From: Erin Moore
Sent: Wednesday, August 13, 2014 4:12 PM
To: Kaycee Hathaway
Cc: Holly Duncan; Joe Gilbert
Subject: RE: Notice to Agencies: BL-14-00014 Suckett

From: Kaycee Hathaway
Sent: Thursday, August 07, 2014 9:50 AM
To: Christina Wollman; Brenda Larsen; Jan Ollivier; Holly Duncan; Erin Moore; Joe Gilbert
Subject: Notice to Agencies: BL-14-00014 Suckett

PROPOSED LAYOUT

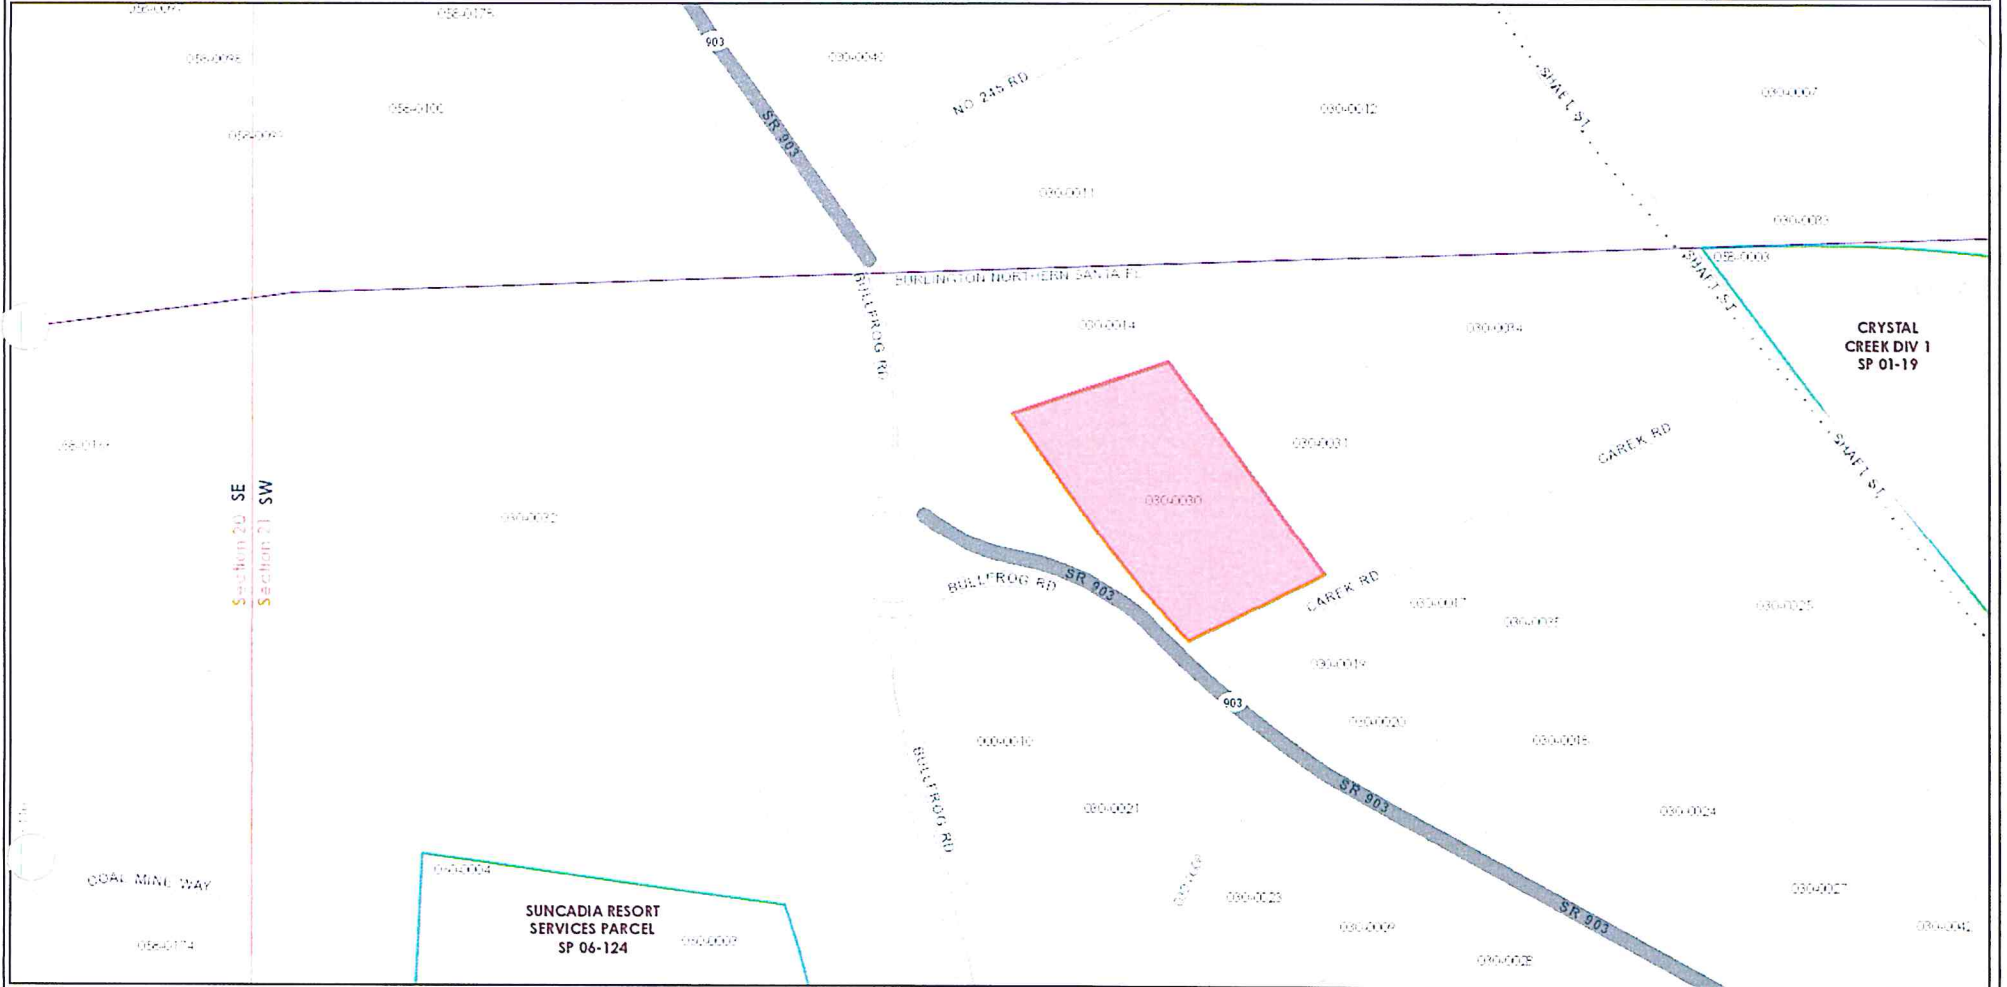
We cannot comment until we have septic and well locations listed.
